KIRKLEES METROPOLITAN COUNCIL INVESTMENT & REGENERATION SERVICE

Reference No:	2026/44/91435/W
Site Address:	Land off, Bankfield Drive, Holmbridge, Holmfirth, HD9 2PH
Description:	Discharge of conditions 26 (boundary treatments, retaining walls, and gabions) and 28 (landscaping) on previous permission 2023/91212 for erection of 21 dwellings with access from Laithe Avenue
Recommending Officer:	Ellie Thornhill

DECISION – Discharge of Condition – Approve

Description: Discharge of conditions 26 (boundary treatments, retaining walls, and gabions) and 28 (landscaping) on previous permission 2023/91212 for erection of 21 dwellings with access from Laithe Avenue.

TITLE  
**EXTERNAL LEVELS  
LAYOUT PLAN**

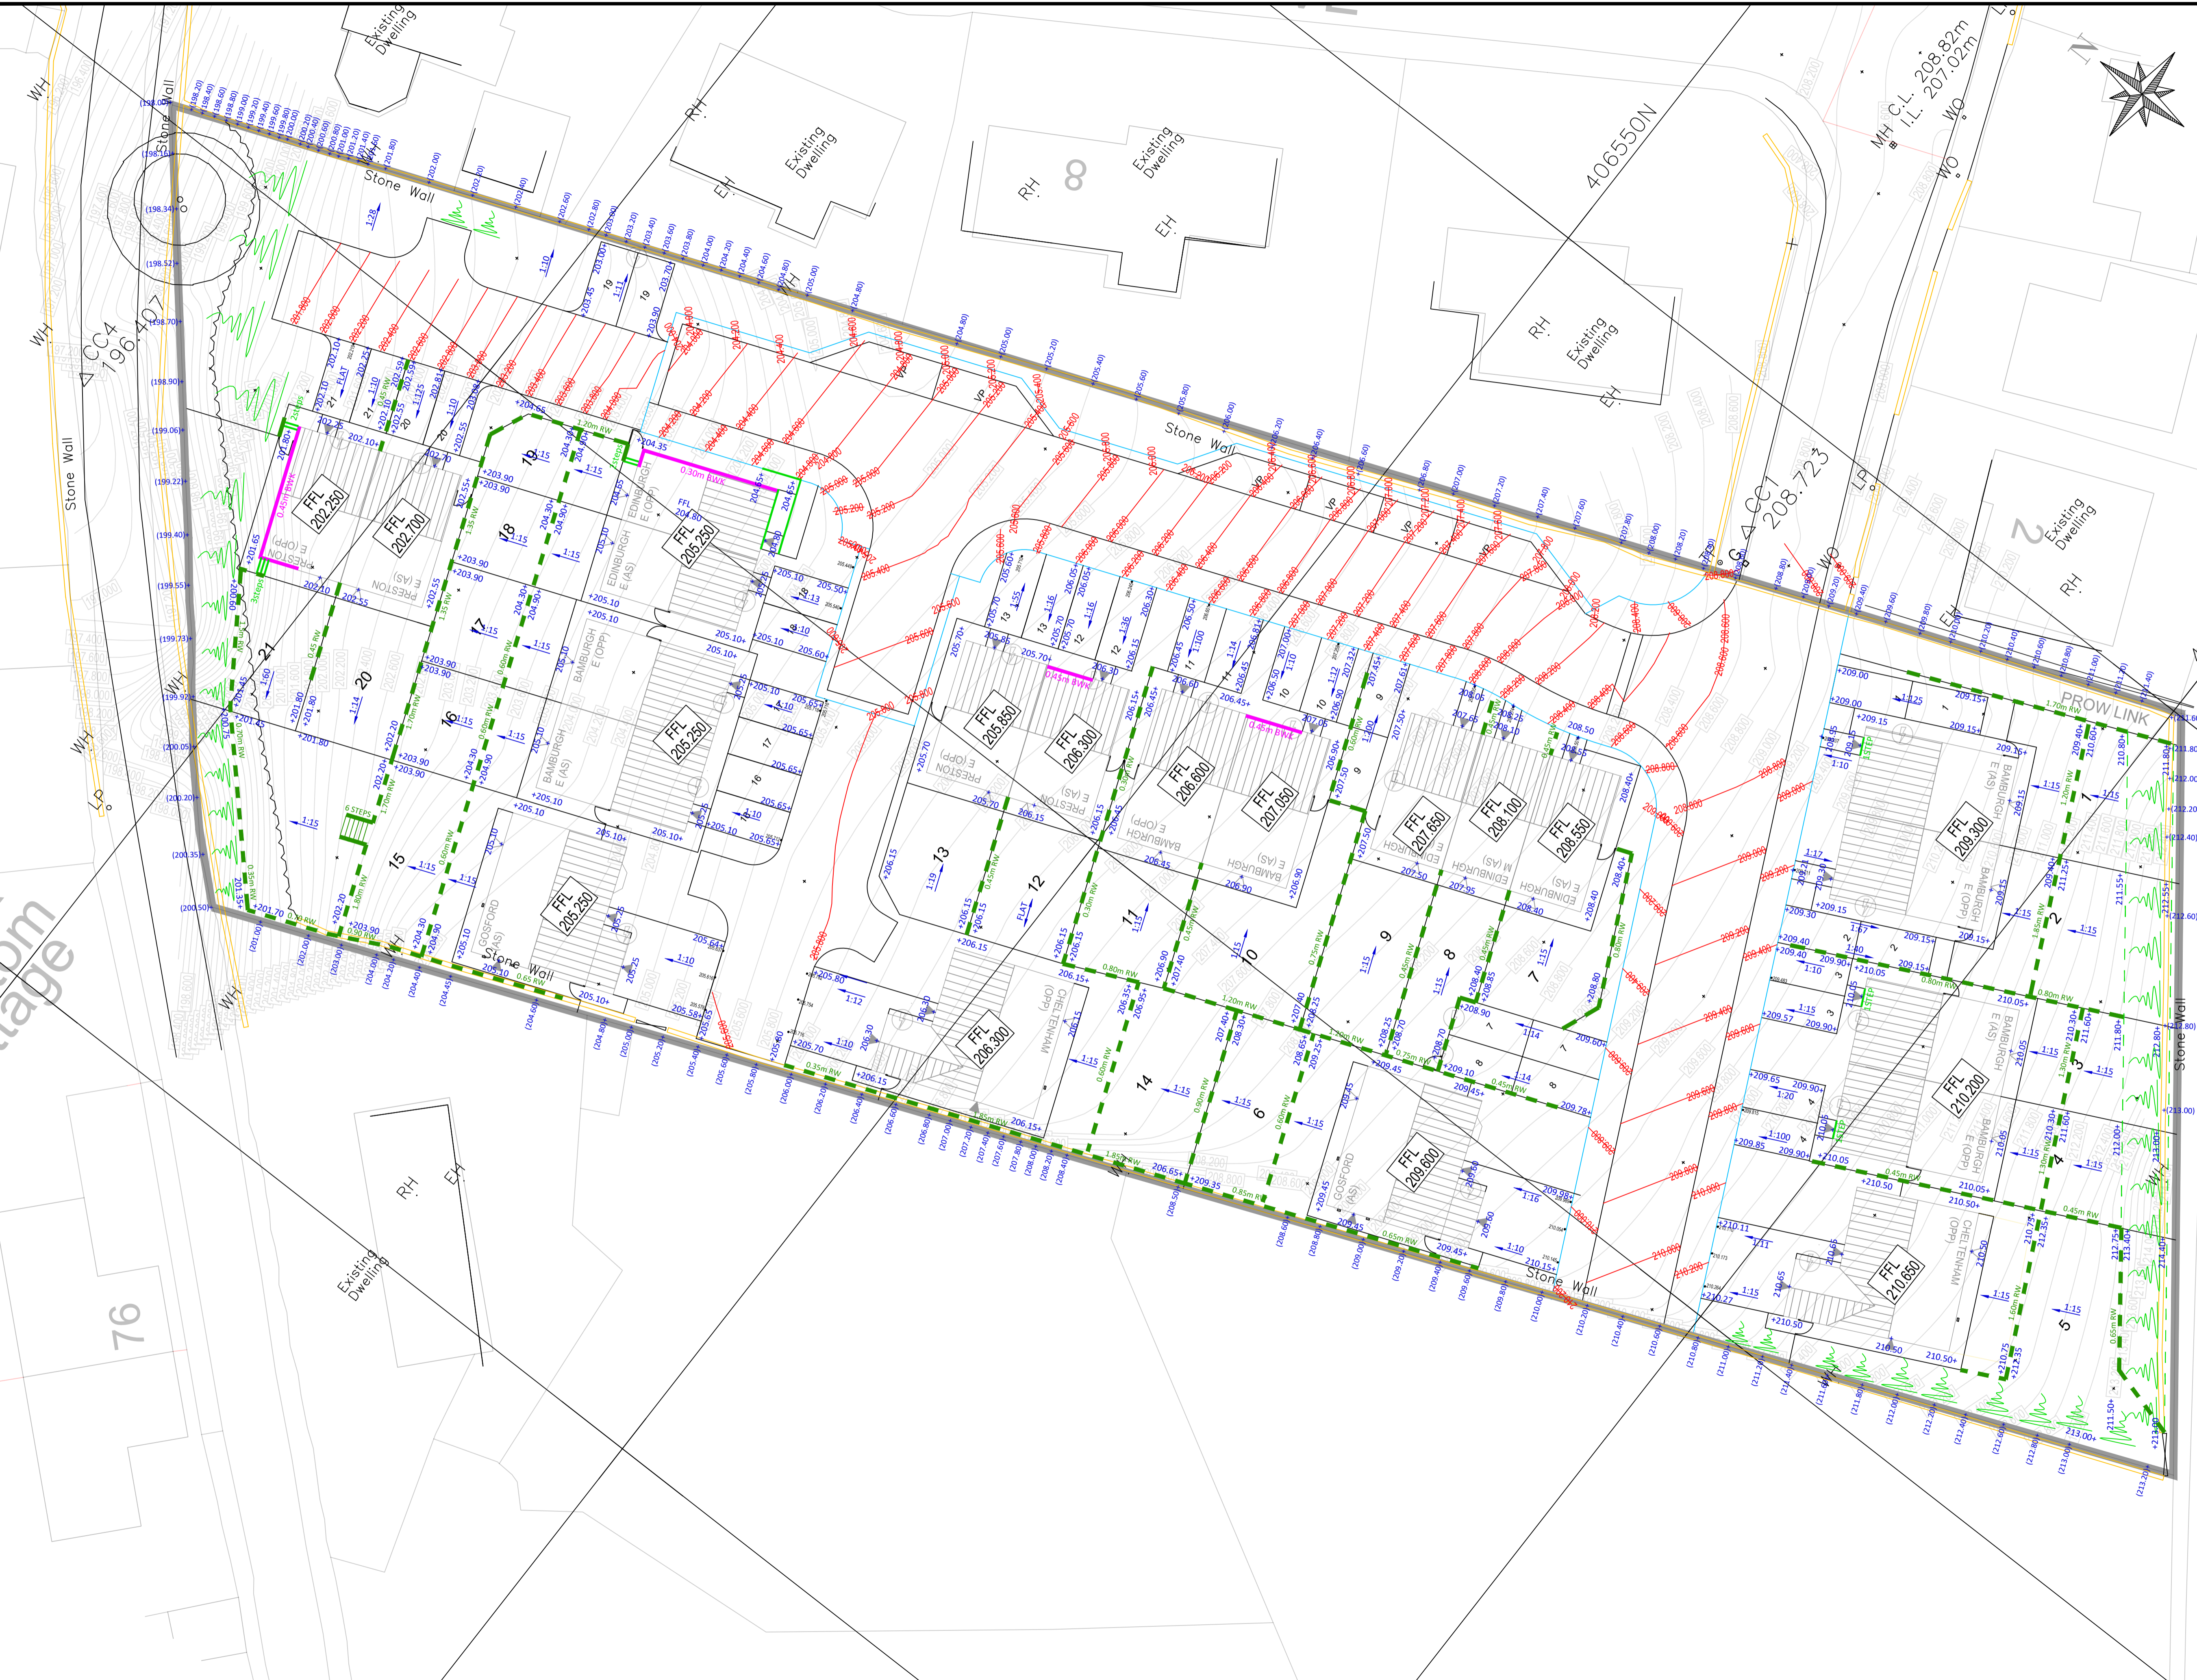
These details can be found on the External Levels plan, and are acceptable.

Date: 08.04.26	Project: Bankfield Drive, Holmbridge
Scale @ A3: 1:500	Drawing Number: 2400-02-008 Boundary Treatments
Drawn By: CD	Revision: D

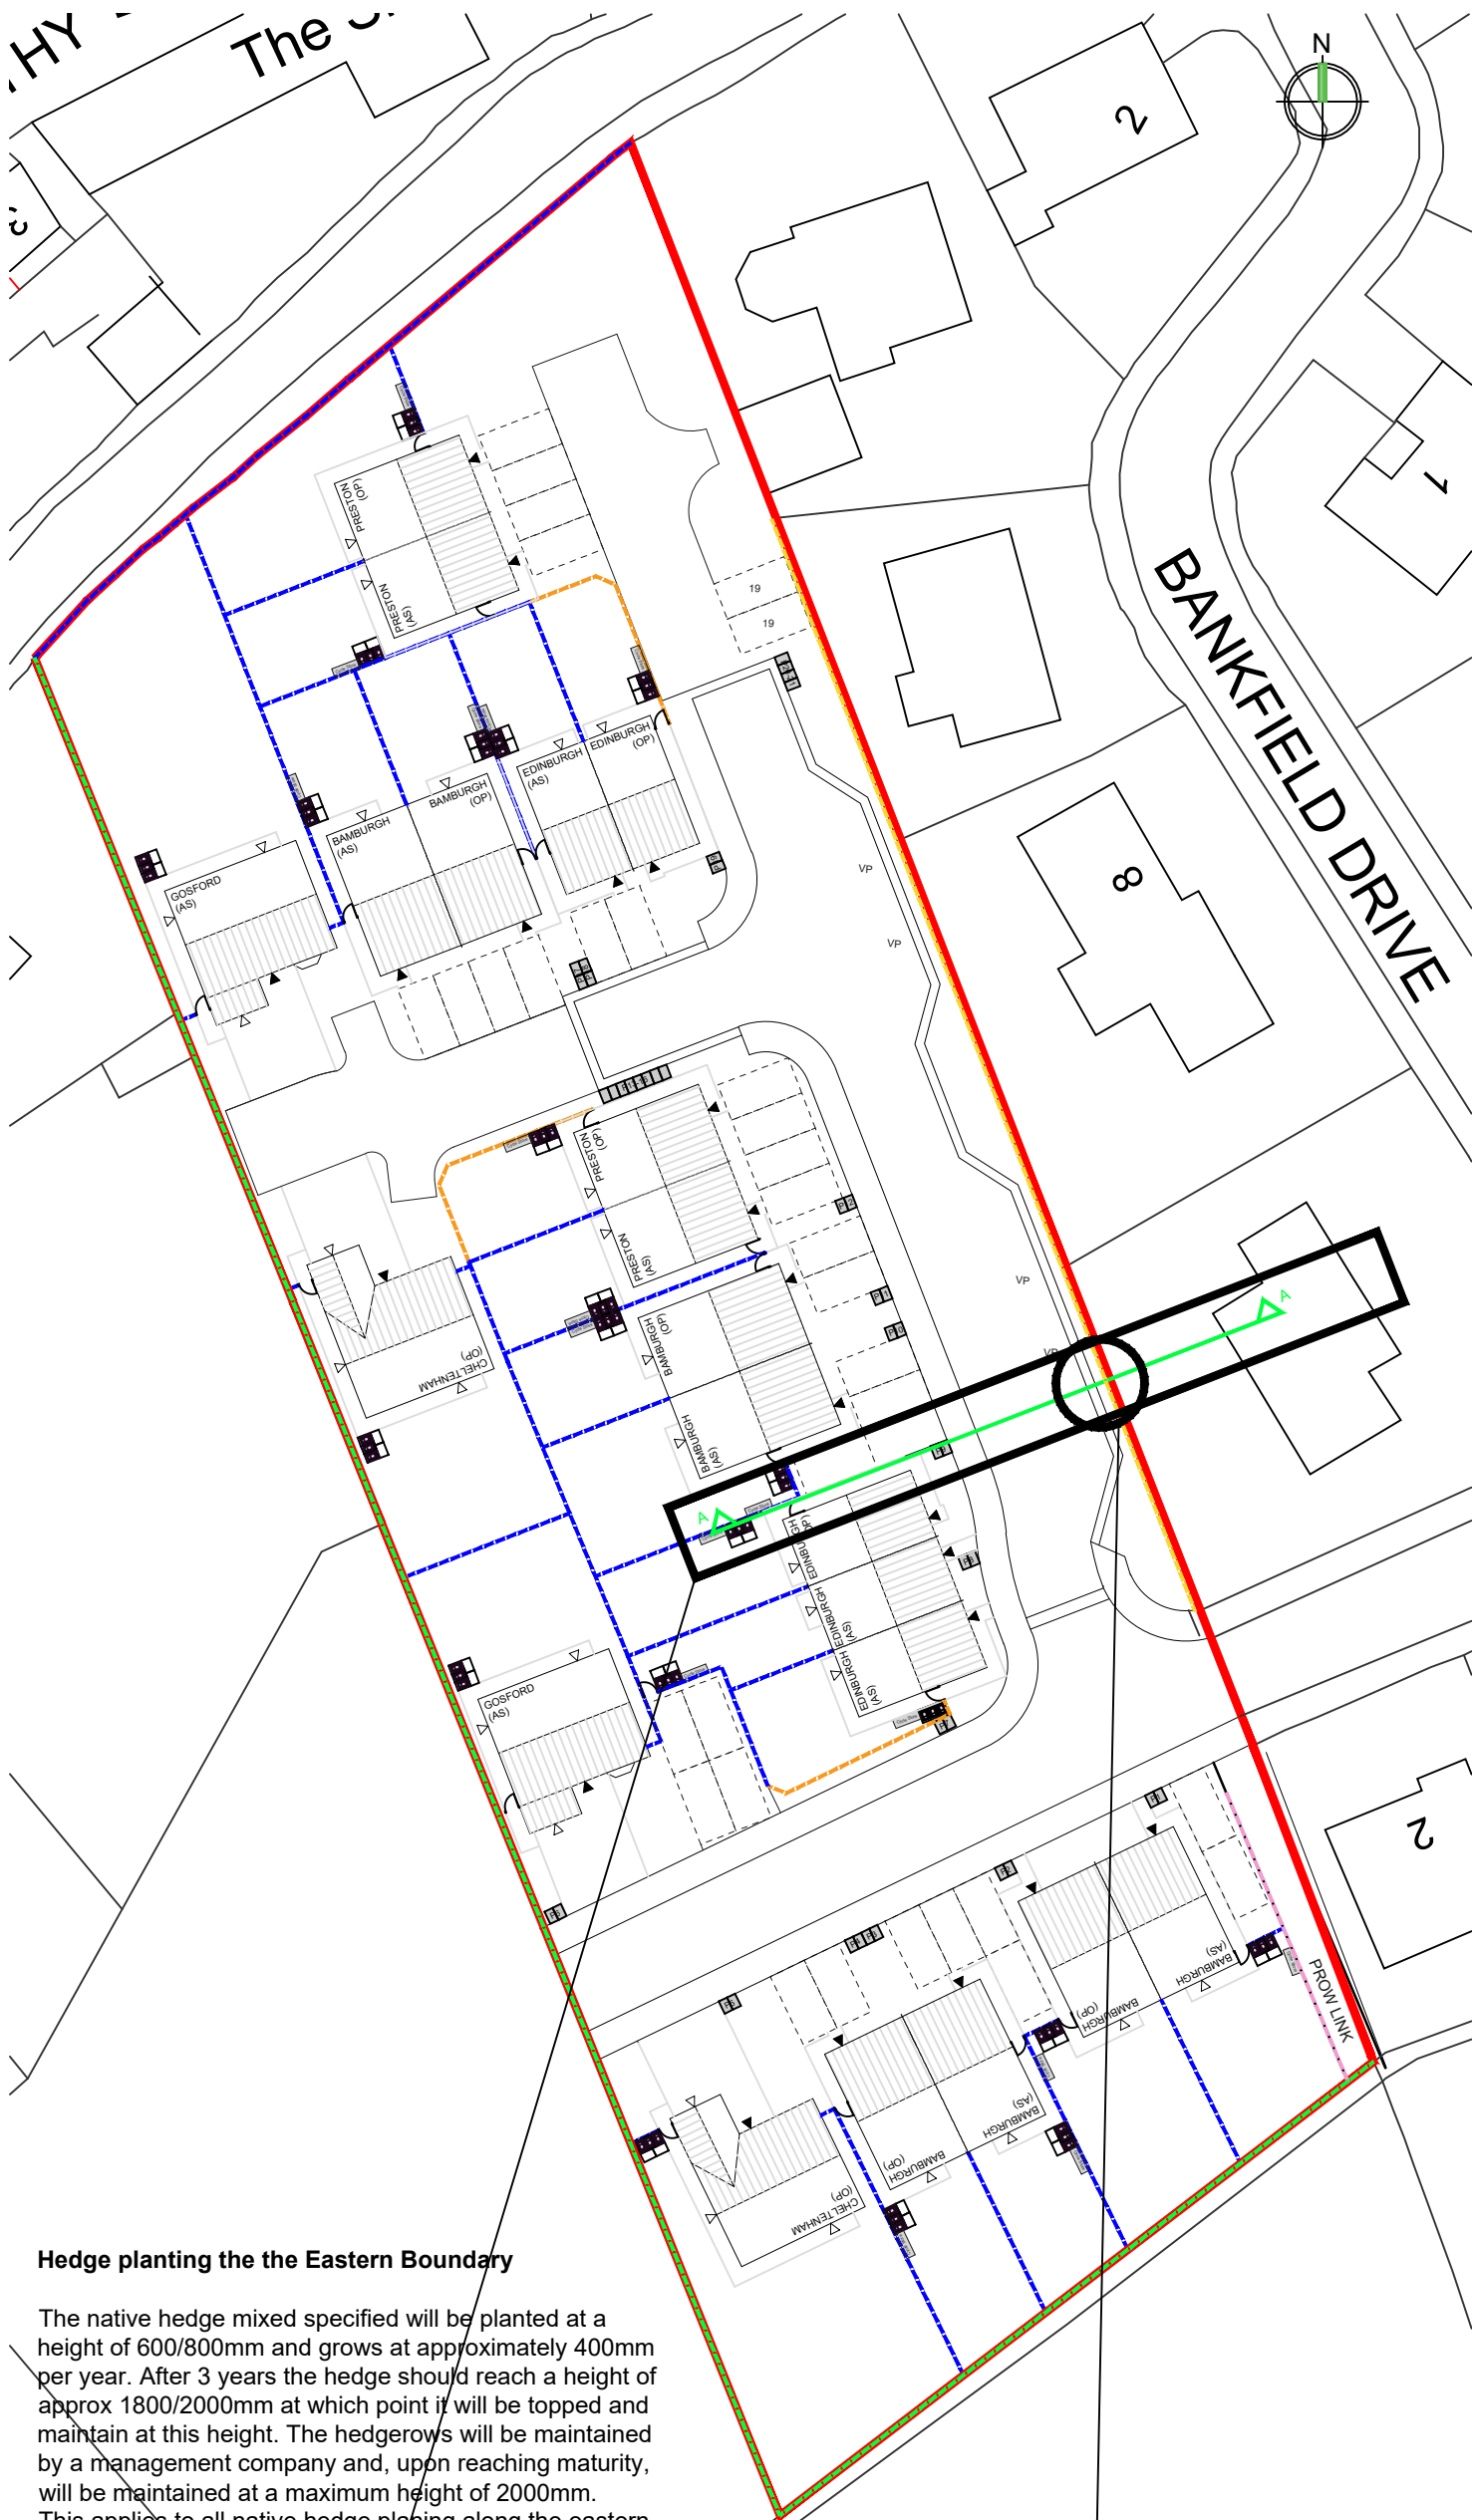
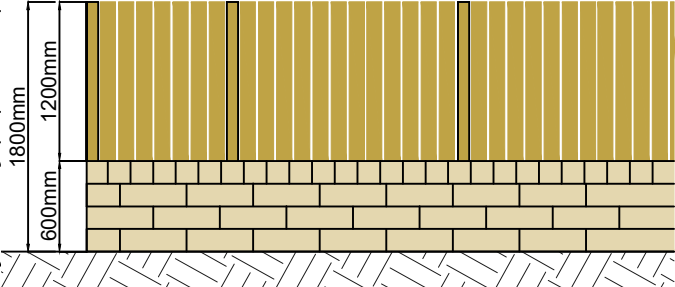
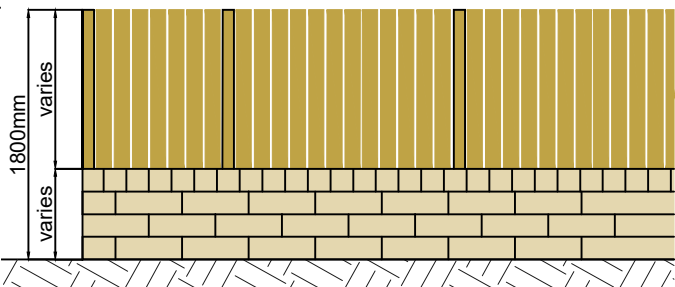
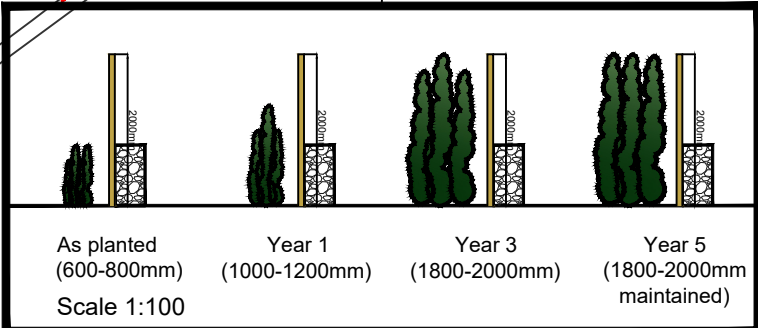
The submitted Boundary Treatment plan identifies timber fencing to the majority of rear garden boundaries, incorporating hedgehog access holes and associated signage. For corner plots adjacent to the highway, particularly Plots 7, 13 and 19, the proposed rear boundary treatment comprises a 600mm-high stone wall, constructed in materials to match the dwellings, with a 1.2m-high hit-and-miss fence above.

Along the site perimeter, the existing dry stone walls are to be retained and repaired where necessary. To the eastern boundary, a 2m-high fence is proposed alongside hedge planting. The fence will provide an immediate means of protecting neighbouring residential amenity, in accordance with the requirements of the condition, whilst the proposed planting establishes. The submitted details indicate that the hedge will achieve its maintained height of approximately 1.8-2m within 3 to 5 years, at which point it will provide effective screening of the fence.

The submitted plan also identifies a hit-and-miss fence above an associated retaining wall adjacent to the proposed pedestrian connection on the southern boundary of the site. However, these works are also subject to Condition 12 (Pedestrian Connection), which is currently being considered under application 2026/91462. For the purposes of Condition 26, the proposed timber fencing above the retaining wall is considered acceptable. However, in this case, Condition 12 is considered to take precedent and should the design of the boundary treatment change through the assessment of that application, a further application to re-discharge Condition 26 would be required to secure approval of the revised details. A note to this effect is recommended to be included on the decision notice.

Having considered the submitted details, the proposed boundary treatments are considered acceptable in terms of flood routing, safeguarding neighbouring residential amenity, deterring crime and anti-social behaviour, and facilitating the movement of hedgehogs through the development.

Further to the above, there is noted to be overlap between condition 26 and condition 12, in relation to the boundary treatment adjacent to the proposed pedestrian connection on the southern side of the site. For the avoidance of doubt, condition 12 is deemed to take precedence: should the boundary treatment adjacent to the proposed pedestrian connection on the southern side of the require amended, contrary to the details hereby approved (for the purposes of condition 26 only), under application 2026/91462, a subsequent application to re-discharge Condition 26 may be required to secure approval of the revised details.
